**RE: Sydney Grammar School, Weigall Sports Complex: State Significant Development (SSD-10421):  
Response to Condition B1**

This letter on the Sydney Grammar School Weigall Sports Complex (SSD-10421) is written on behalf of Sydney Grammar School. It responds to SSD-10421 Condition B1 which states:

- B1. Prior to the issue of any construction certificate, the design of Building 1 (Sports Complex building) must be amended and revised architectural plans and documentation demonstrating compliance with the condition must be submitted to, and approved by, the Planning Secretary. The revised design must modify the design of that part of Building 1 located directly opposite 8 Vialoux Avenue (i.e. the building component east of the Building 1 stair core/Multipurpose Hall 4 and including the area above the program pool) to reduce the view loss impact experienced by the north facing living rooms within apartments 1, 5, 8 and 12 at 8 Vialoux Avenue. The amendments to the design must comprise (unless otherwise agreed with the Planning Secretary) the following:

Drawing Title
**WEIGALL SPORTS COMPLEX
BUILDING 01 AND BUILDING 02
APPROVED SSDA / RESPONSE TO B1
CONDITION COMPARISON (SHEET 5)**

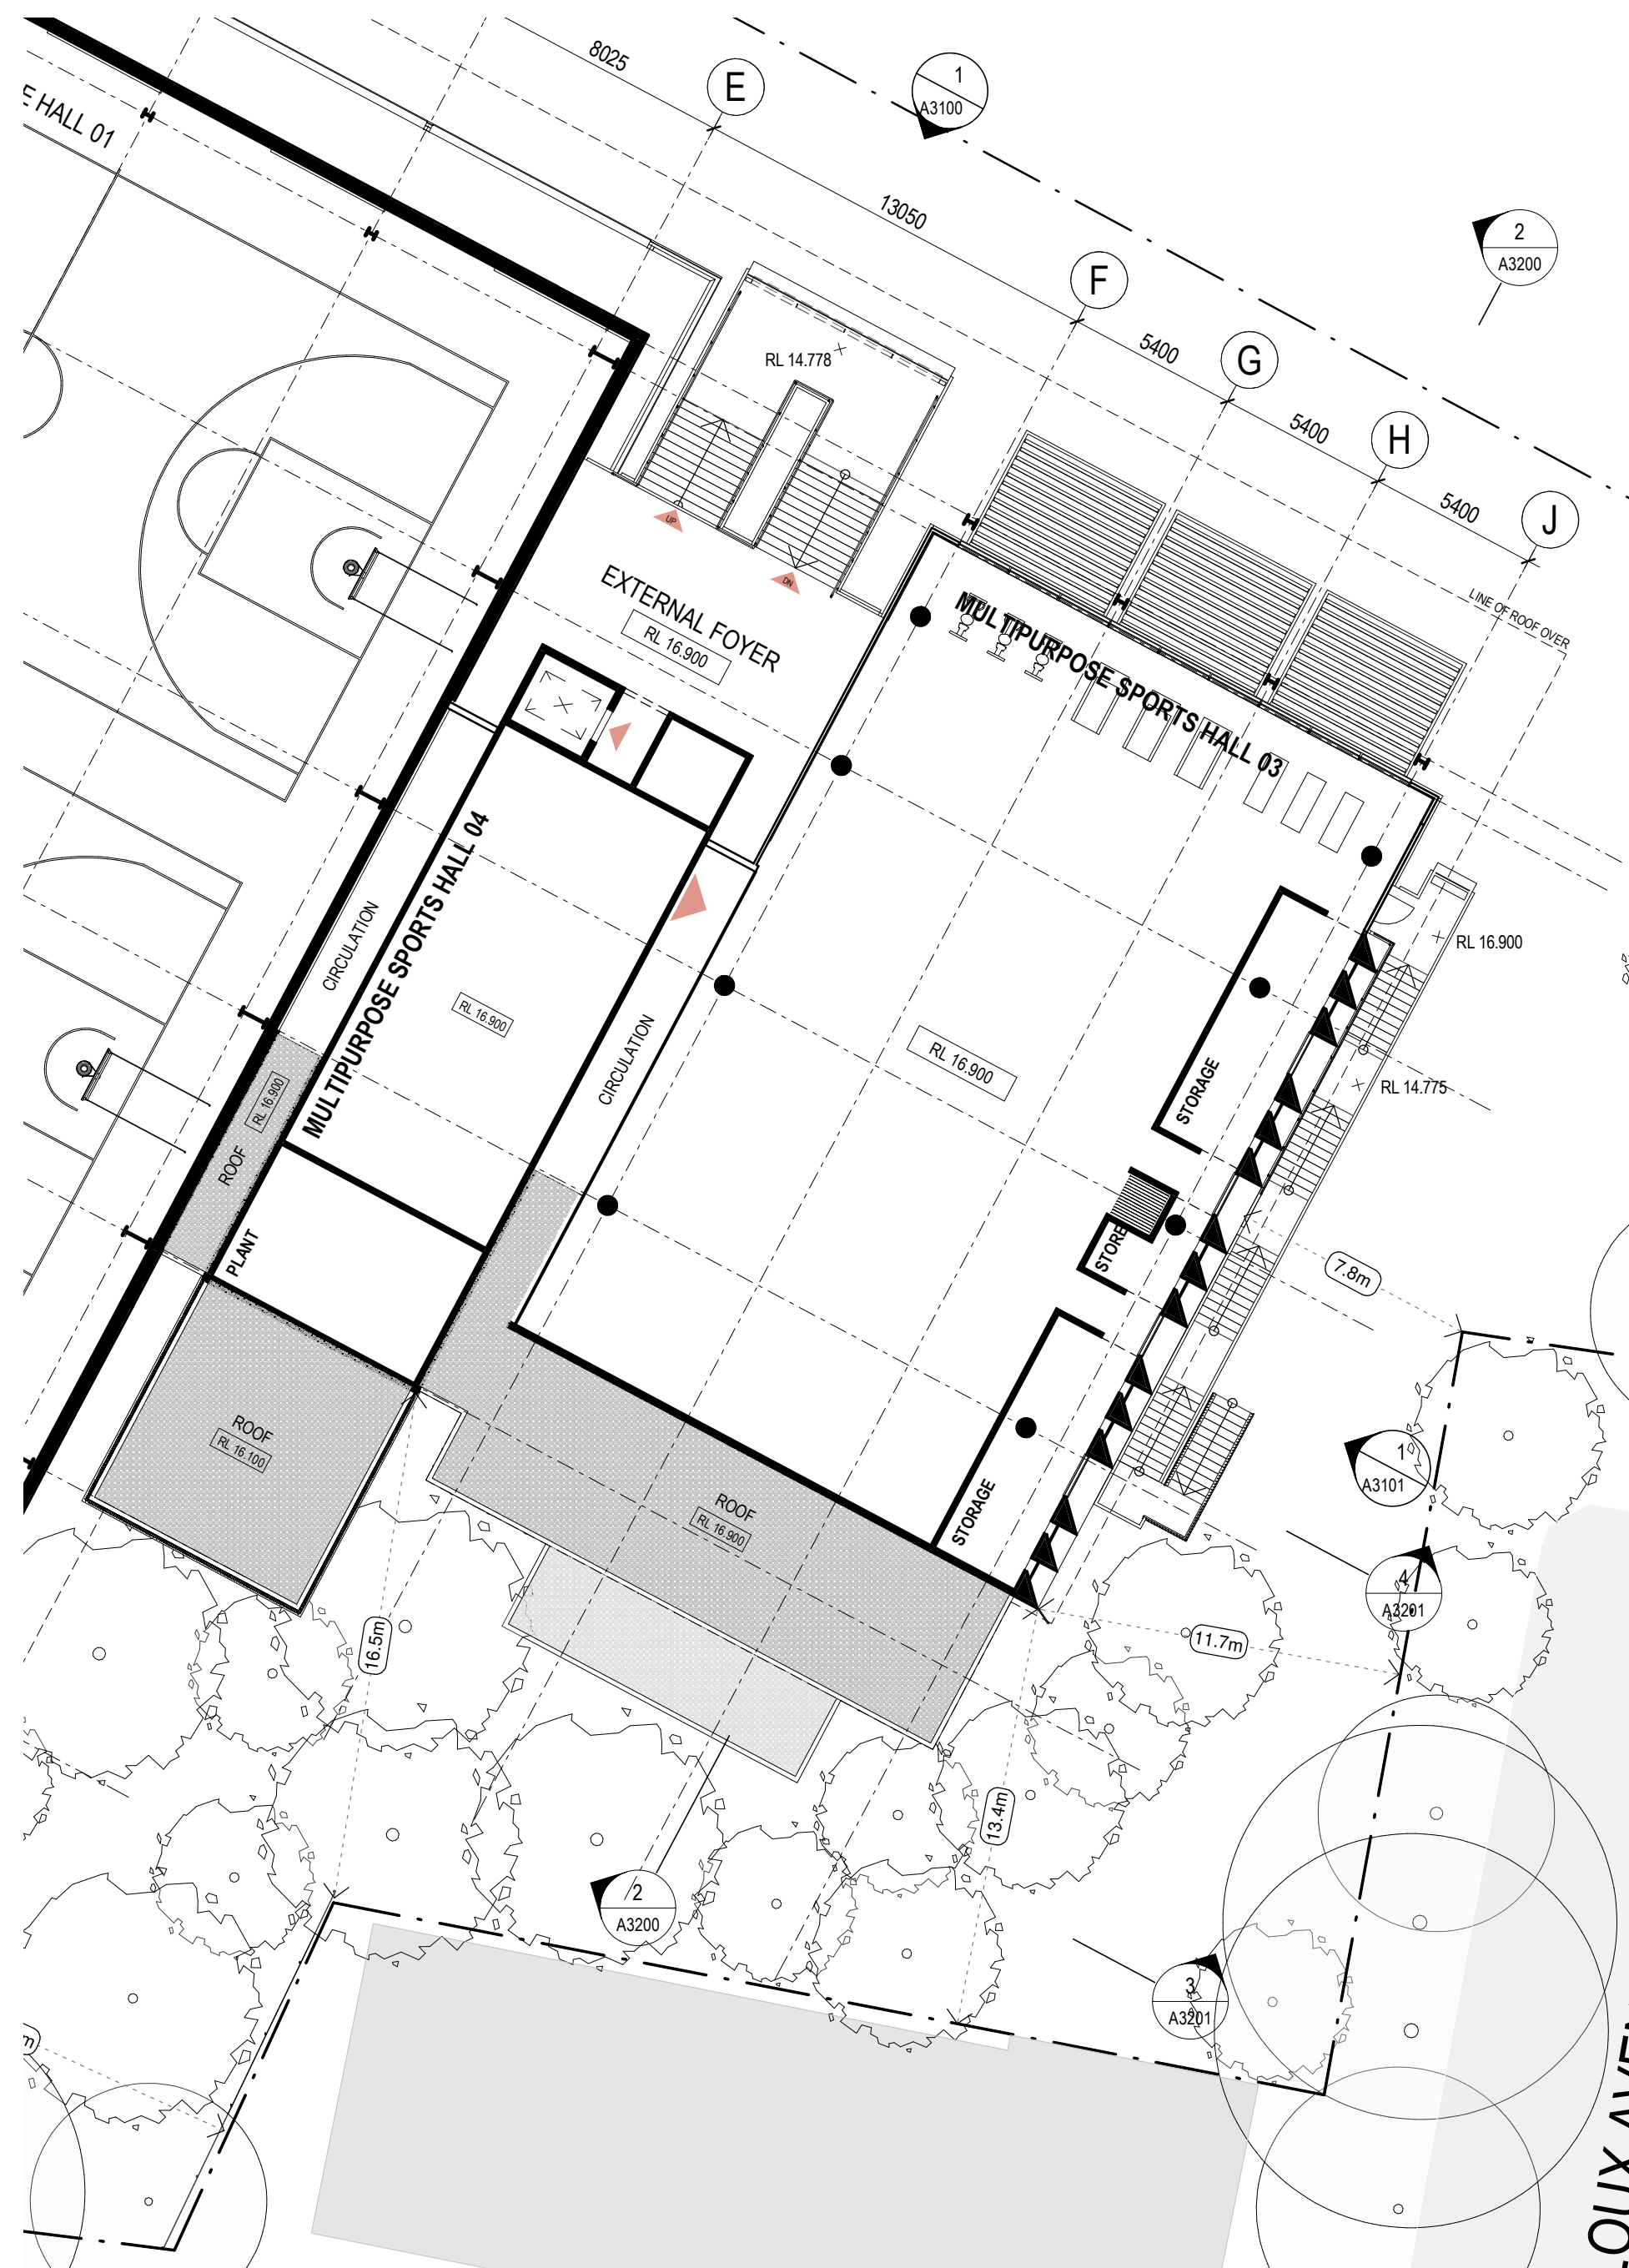
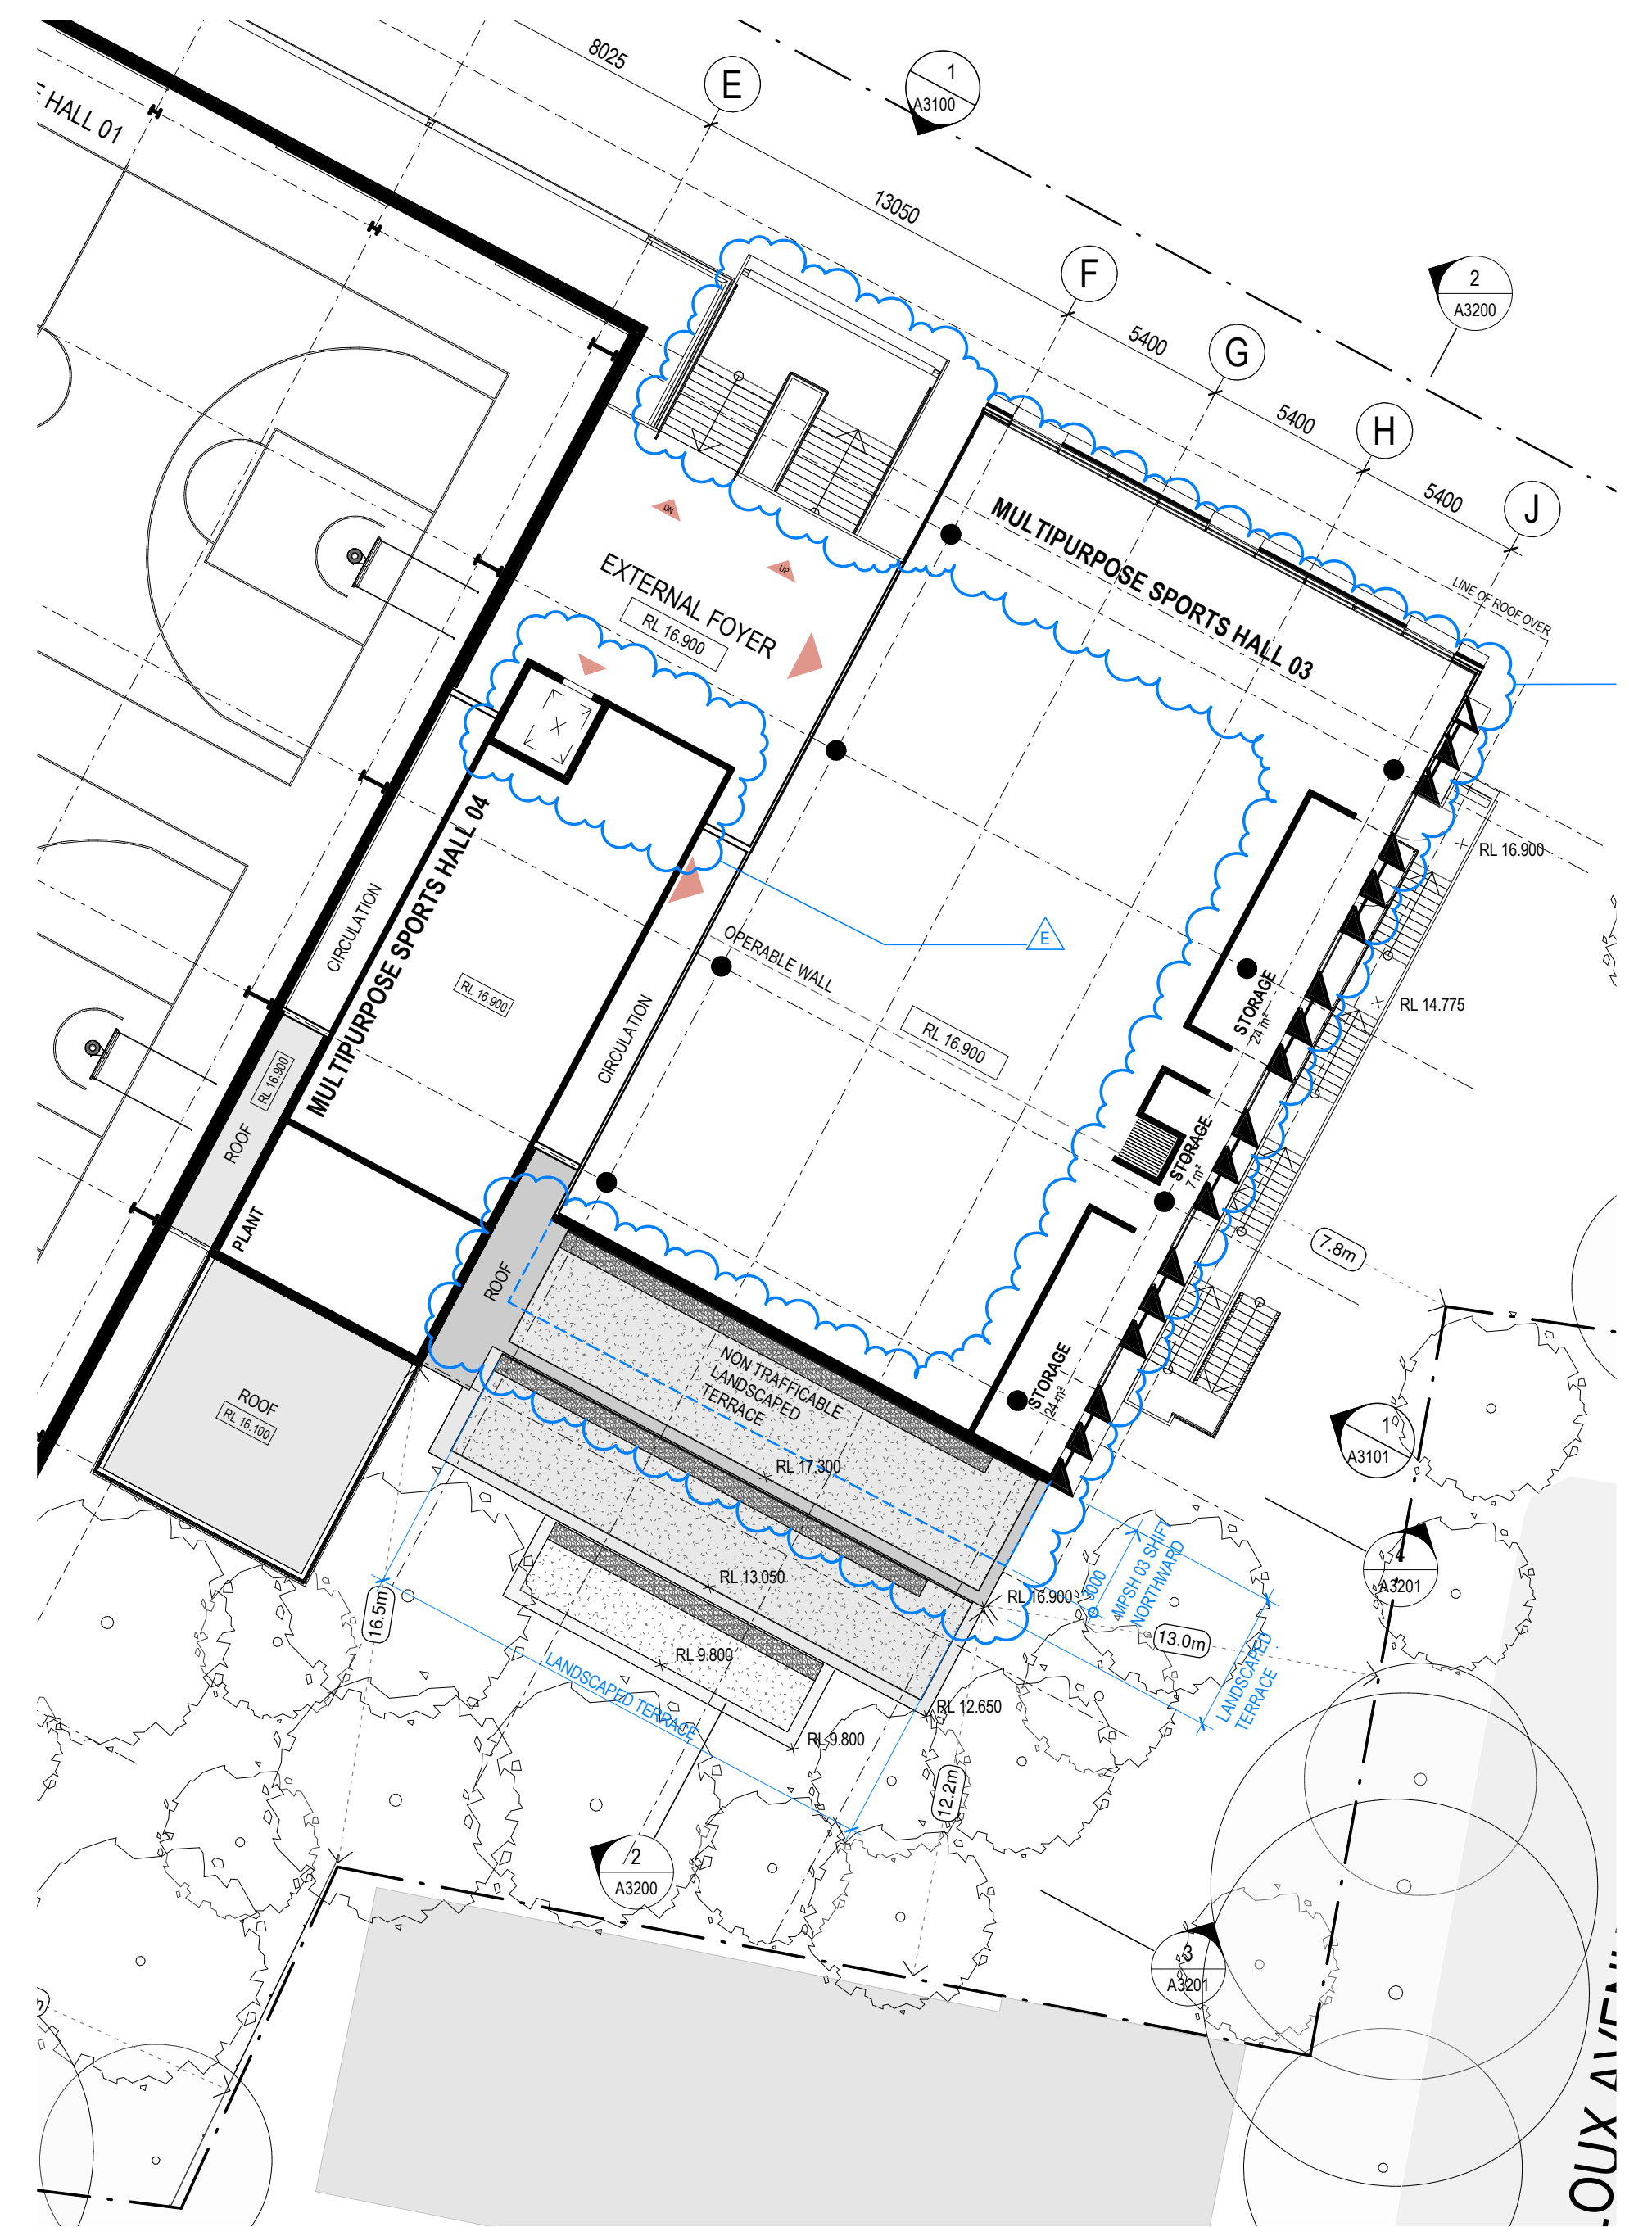
1. Level 1, Multipurpose Sports Hall 2 (see **Figure 1**):
  - Relocated **4m** northward to increase the southern boundary setback
  - Non-trafficable landscaped terrace to the new setback area
2. Level 2, Multipurpose Sports Hall 3 (see **Figure 1**):
  - Relocated **3m** northward to increase the southern boundary setback
  - Non-trafficable landscaped terrace to the new setback area

- (b) relocate the floor plate of the portion of Level 2 accommodating Multi-Purpose Sports Hall 3 further northward by **3m**, to increase the setback of this part of Building 1 to the southern boundary;

- (d) include non-trafficable areas (except for maintenance purposes) and provide roof-top planting along the southern edge of the roofs created from the relocation of the floor plates of Levels 1 and 2 further northward (i.e. the 4m and 3m wide roof areas on Levels 1 and 2 respectively, facing the apartments on 8 Vialoux Avenue).
